ENGAGEMENT REPORT

Mixed Use Development comprising a Hotel, Commercial Office Premises and a Residential Flat Building

No. 2-4 Burleigh Street and No. 20-24 Railway Parade,

REF: M230306

PAVEMENT FINISHES WITHIN SITE

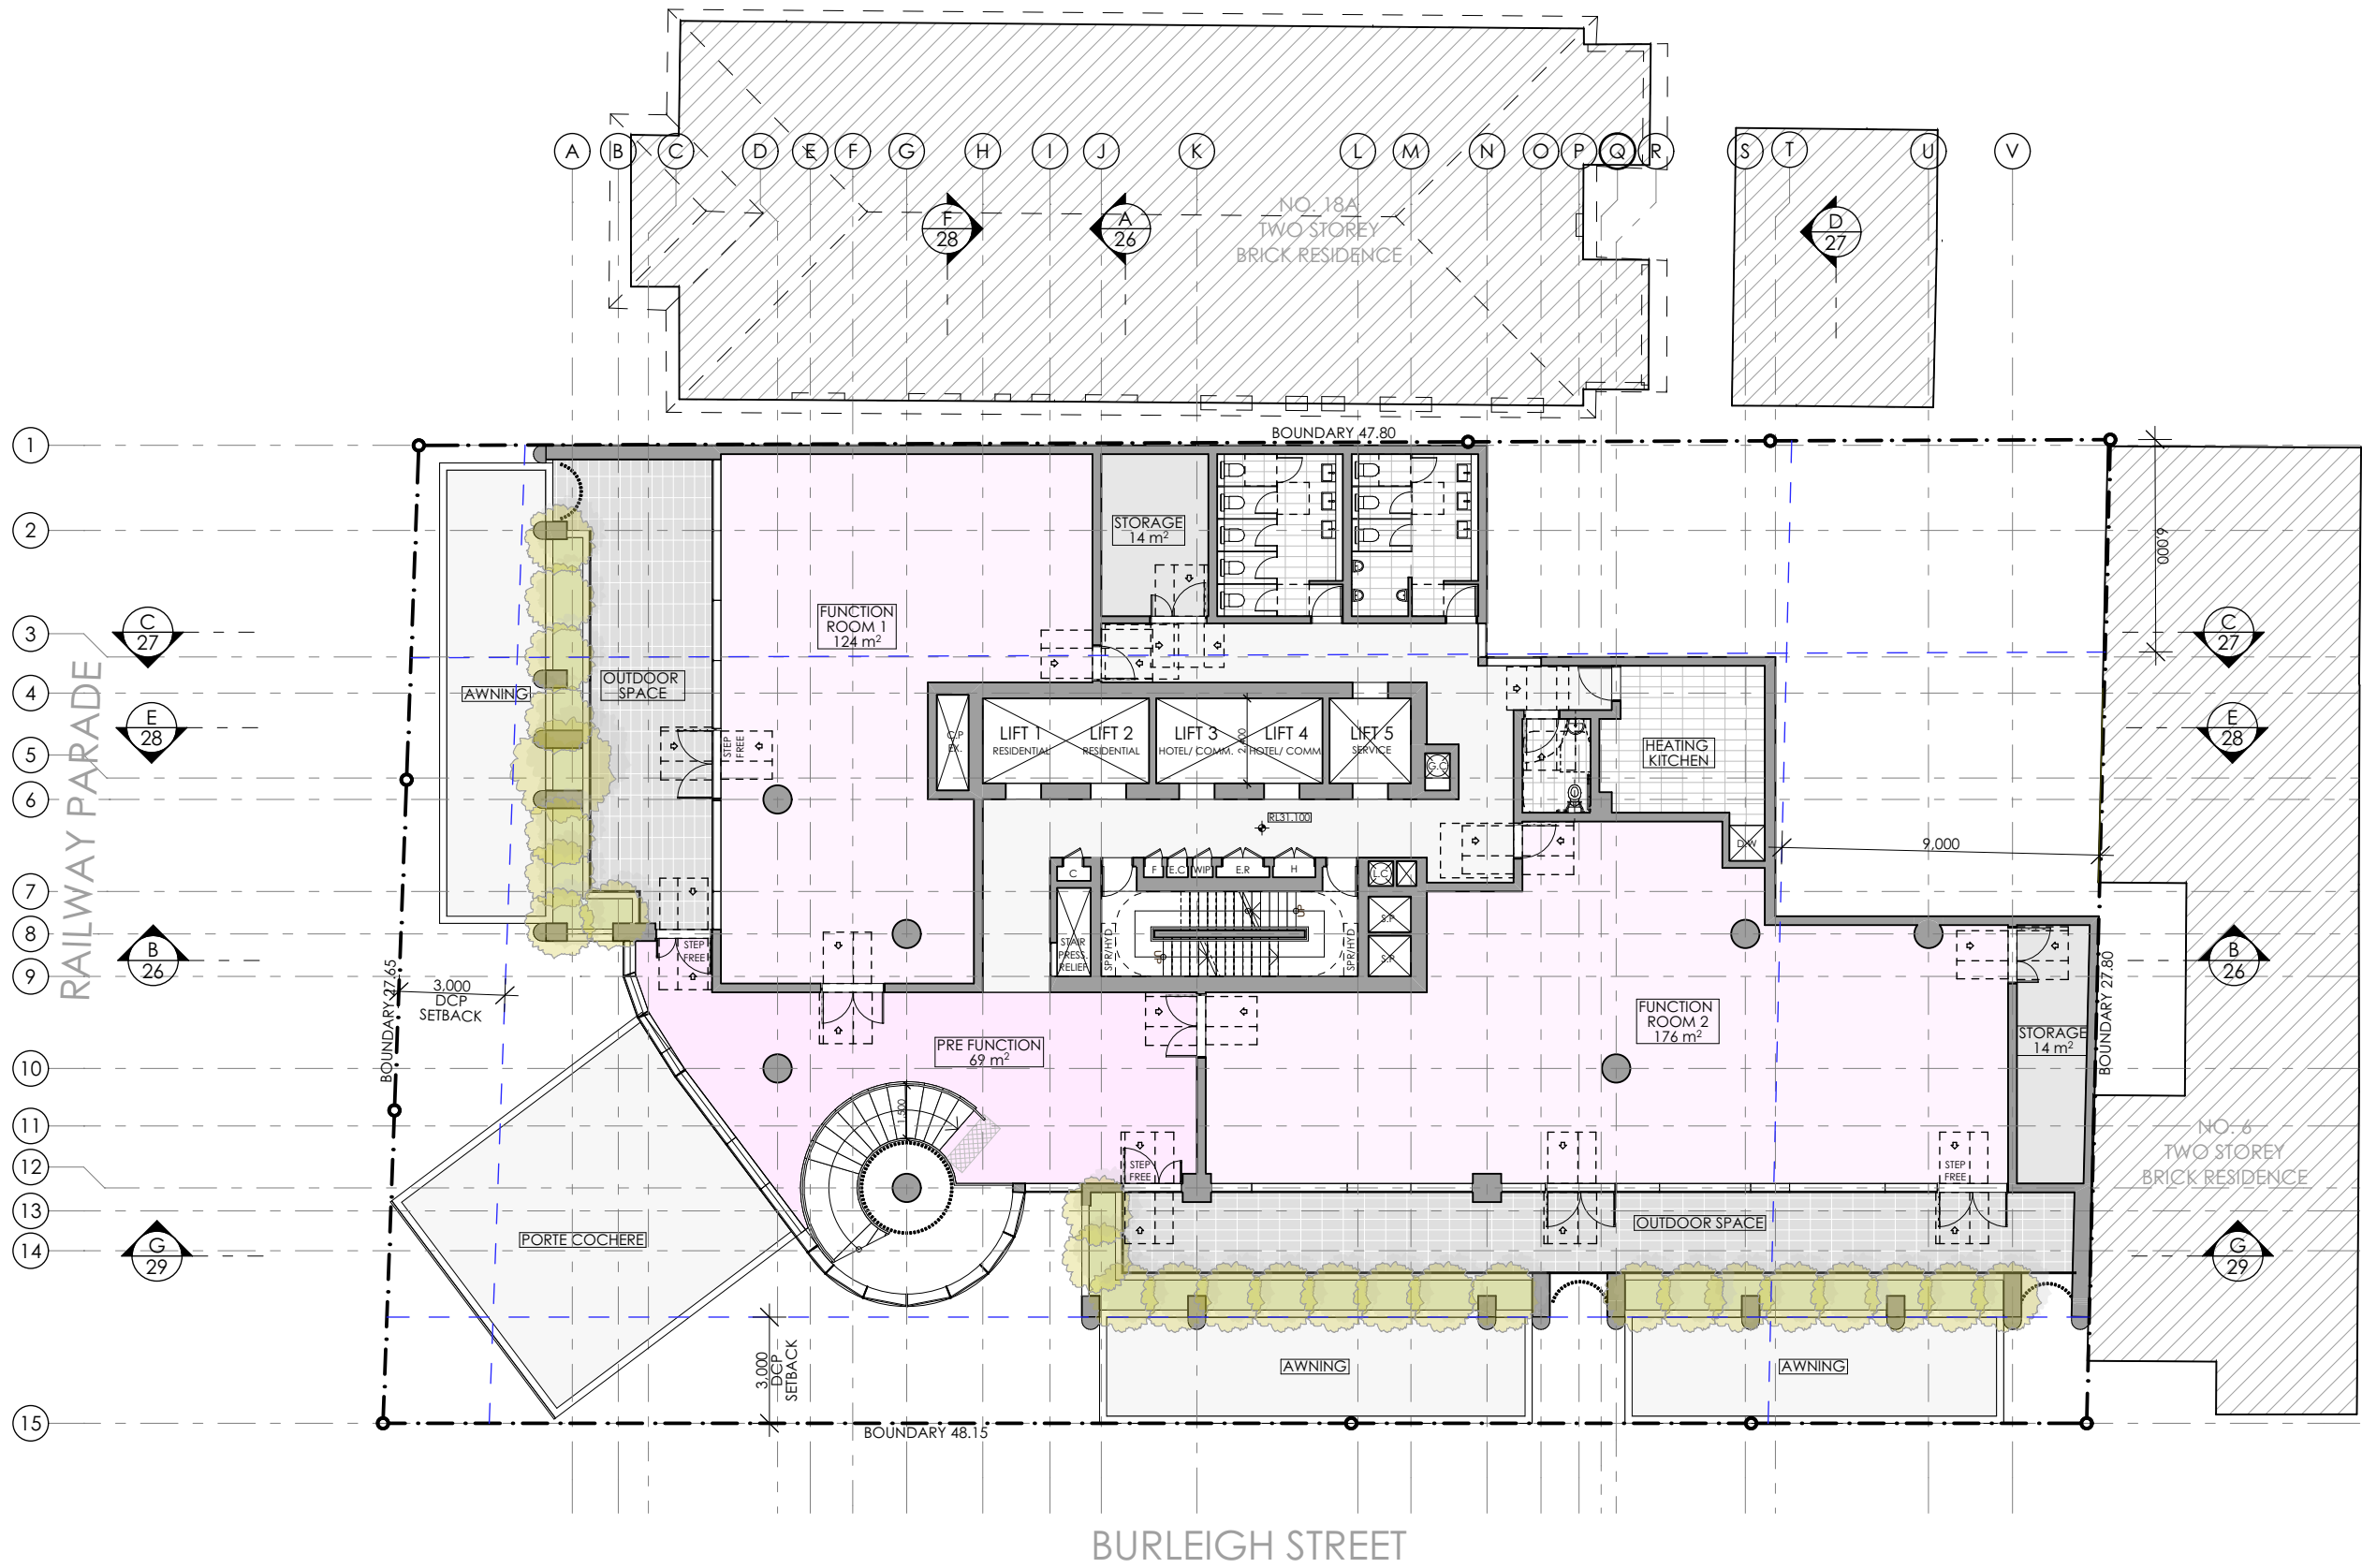
<p><u>Traffic</u></p> <p>The proposed four (4) driveways are not supported.</p> <p>The proximity of the porte-cochere to the intersection of Railway Parade and Burleigh Street is not supported</p>	<p>Refer to Transport and Accessibility Impact Statement at Appendix 26, Waste Management Plan at Appendix 29, Access Report at Appendix 15 and BCA Report at Appendix 16.</p> <p>The site has two street frontages. Burleigh St is a one way street hence why this location is ideal for service vehicles entry/exit and porte-cochere exit only.</p> <p>Locating the basement entry on Burleigh St would be inconvenient and confusing for visitors & hotel guests that would be unfamiliar with the area to navigate entry to the site from Belmore St.</p> <p>The porte-cochere driveway entry at Railway Pde and exit at Burleigh St are a minimum of 6m from the tangent point of the intersection, compliant with AS2890.1:2004 Figure 3.1.</p> <p>Locating the porte-cochere entry on the intersection is the most convenient for drivers that are dropping off/ picking up hotel guests unfamiliar with the area, having to navigate entry to the porte-cochere as Burleigh St is one-way.</p> <p>The porte-cochere location also minimises the crossover of driveway and usable pedestrian space that's valuable for active frontages and public domain footpath.</p>

DRAWING TITLE:
LEVELS 3-8 FLOOR PLAN-
RESIDENTIAL AFFORDABLE
HOUSING

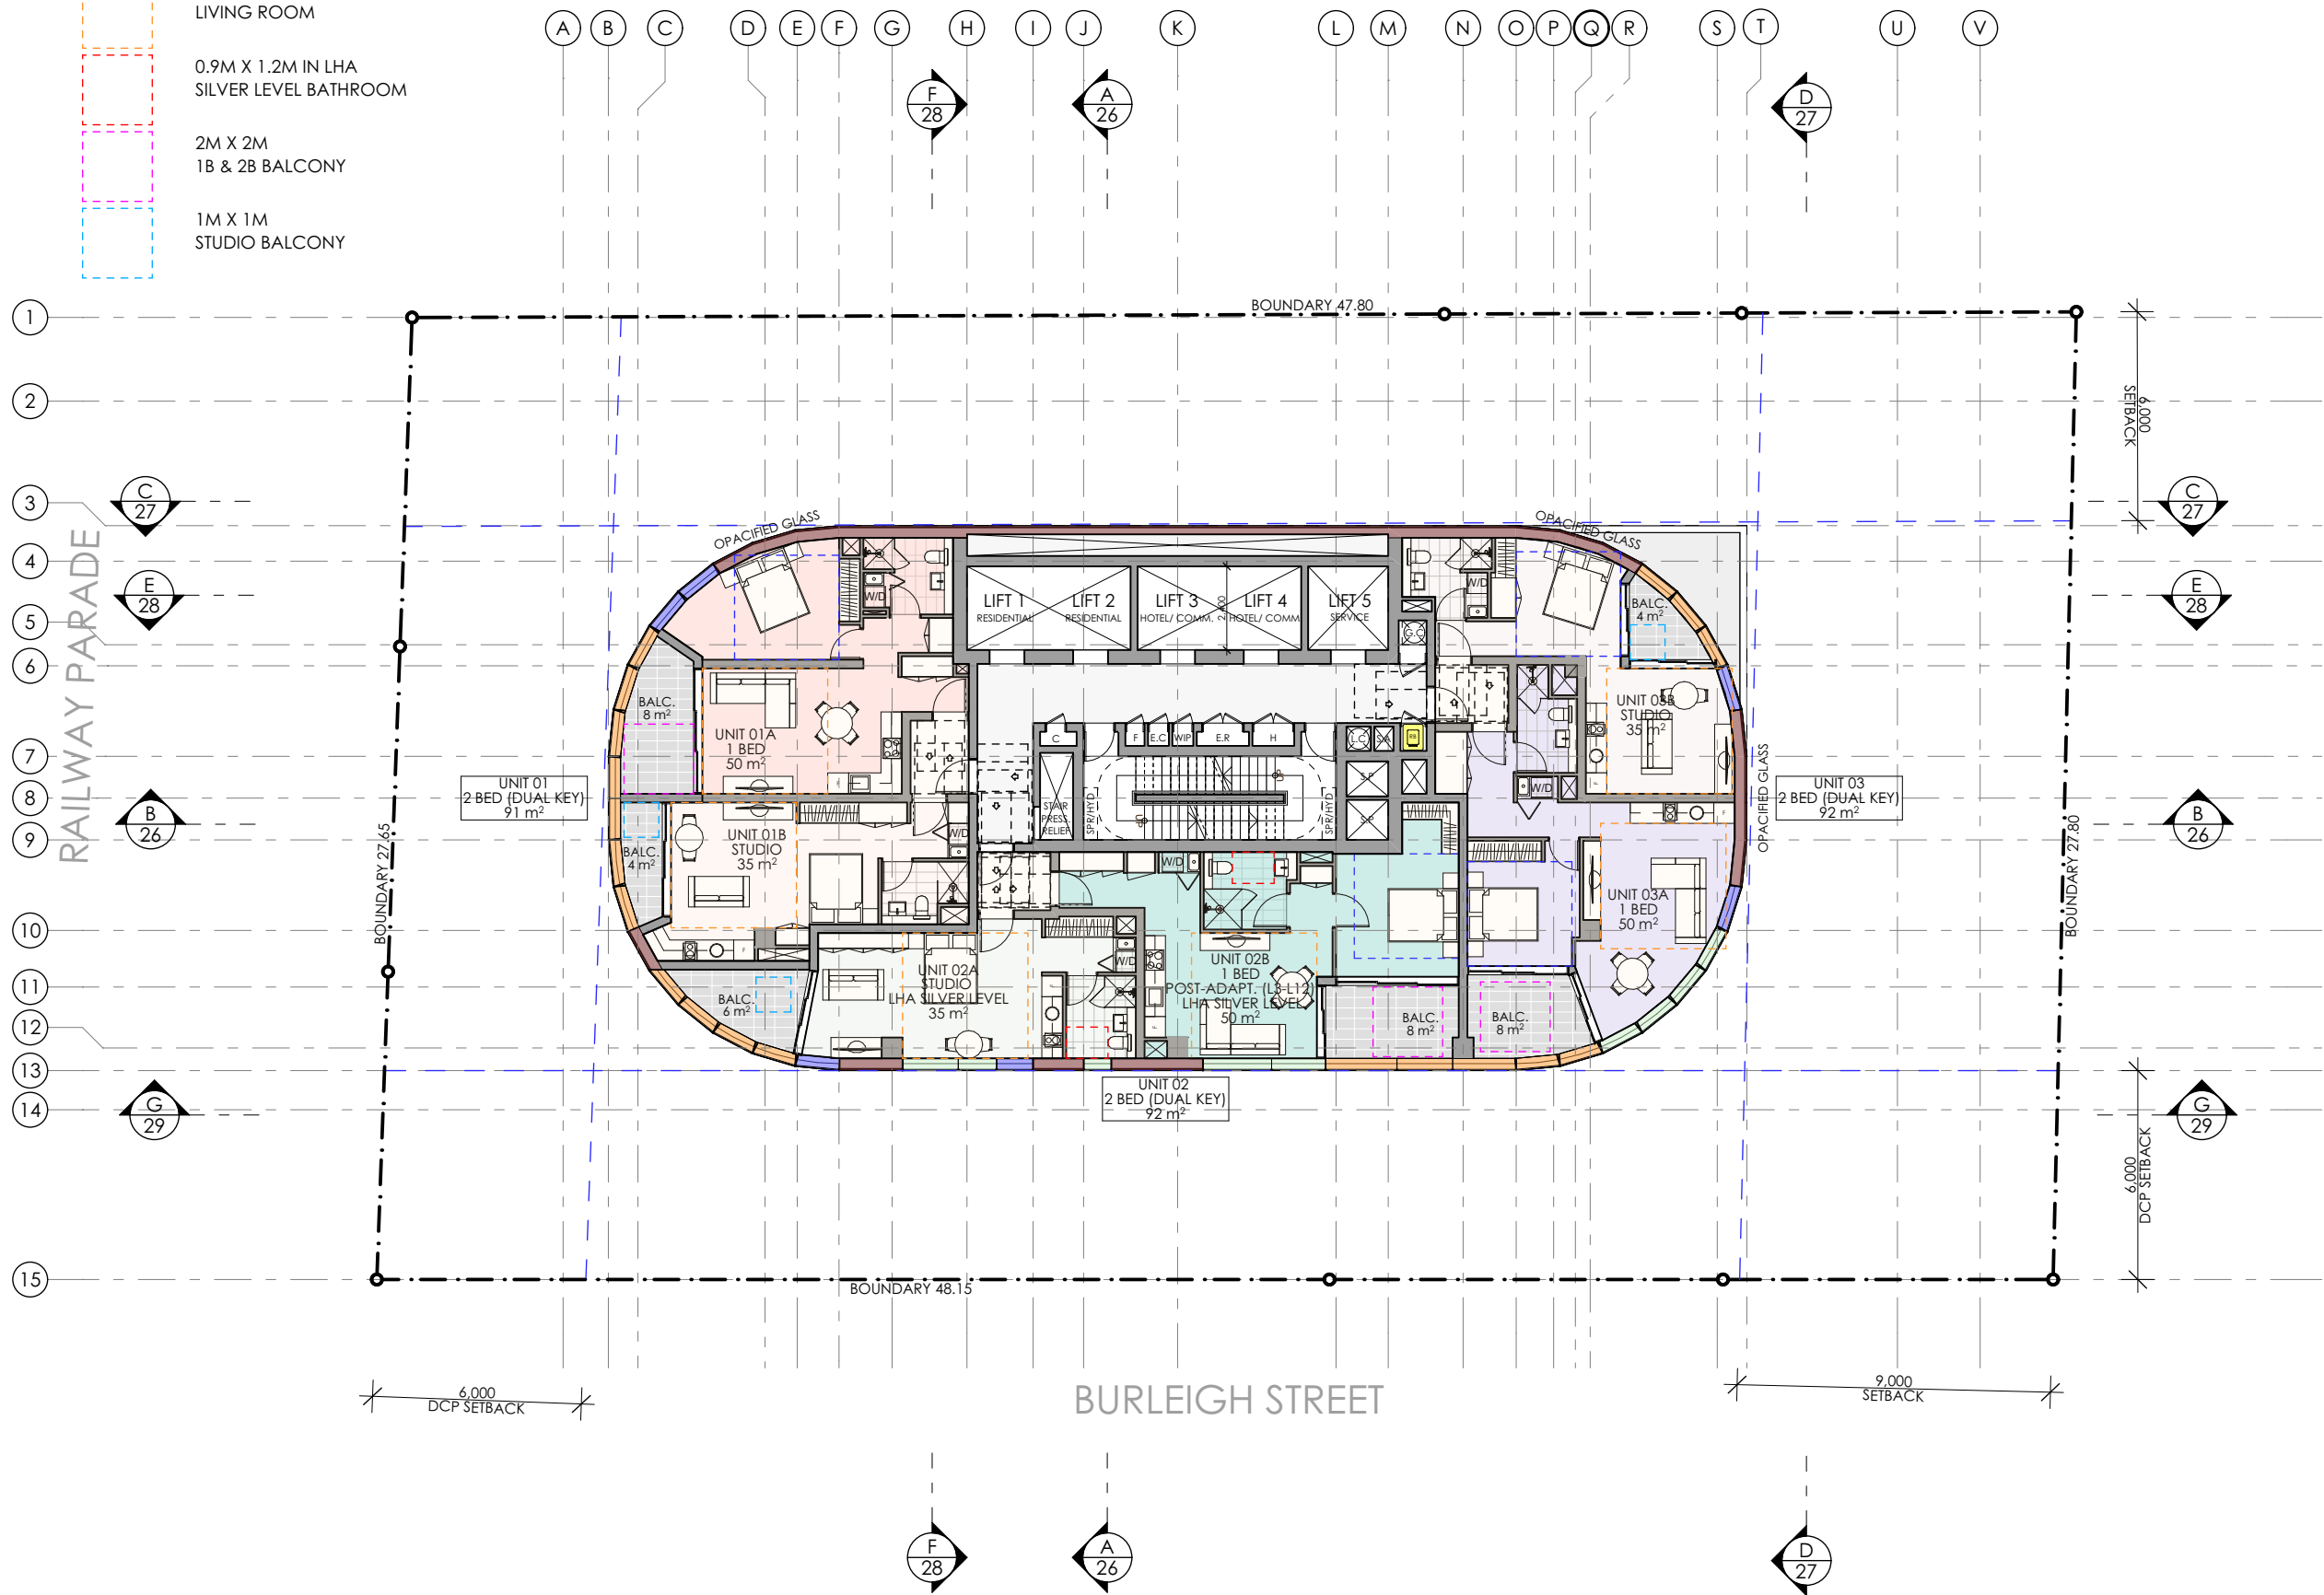
<p>No affordable housing has been depicted on the submitted plans. Further information is to be provided in order for Council to ascertain which units will be used for the purposes of affordable housing.</p> <p>Insufficient information has also been provided with relation to cost of works details.</p>	<p>The affordable housing apartments are now depicted on the submitted Architectural Plans at Appendix 8, specifically the floor plans, sections and apartment schedule. Notably affordable housing is dedicated at Level 3 to 8 and consist of 18 dual key units in total.</p> <p>Refer to the EDC Report at Appendix 5,</p>
<p><u>Heritage</u></p> <p>A heritage assessment of the potential impact on the adjoining locally listed terraces and church is to be provided with meaningful strategies to mitigate impact.</p> <p>The development needs to be set back from north-west corner to provide a curtilage to the church to the west that is listed as a local heritage item.</p> <p>The site previously contain the 'AC/DC house' until demolished by the applicant in December 2024. Any redevelopment is to provide meaningful acknowledgment of the former house and the contribution of the band to Australian music culture.</p>	<p>A HIS has been prepared to accompany this EIS at Appendix 23.</p> <p>The DCP specifically identifies a 3m street front setback to Burleigh Street. This has been provided by the proposal. Furthermore, the north-west corner of the podium is chamfered at 45 degrees, which is significantly more than the minimum 3m requirement.</p> <p>A meaningful acknowledgement to AC/DC can be incorporated into the development in various ways including, but not limited to the potential of incorporating:</p> <ul style="list-style-type: none"> - External public art; - Commemoratives plaques; - Integrated interior design elements; - Themed restaurant located on Level 36 similar to a "Hard Rock Café". <p>Further details will be provided at CC stage.</p>

<p><u>Insufficient Information</u></p>	<p>Refer to Architectural Plans at Appendix 8 and Architectural Design Report and Statement at Appendix 9.</p>
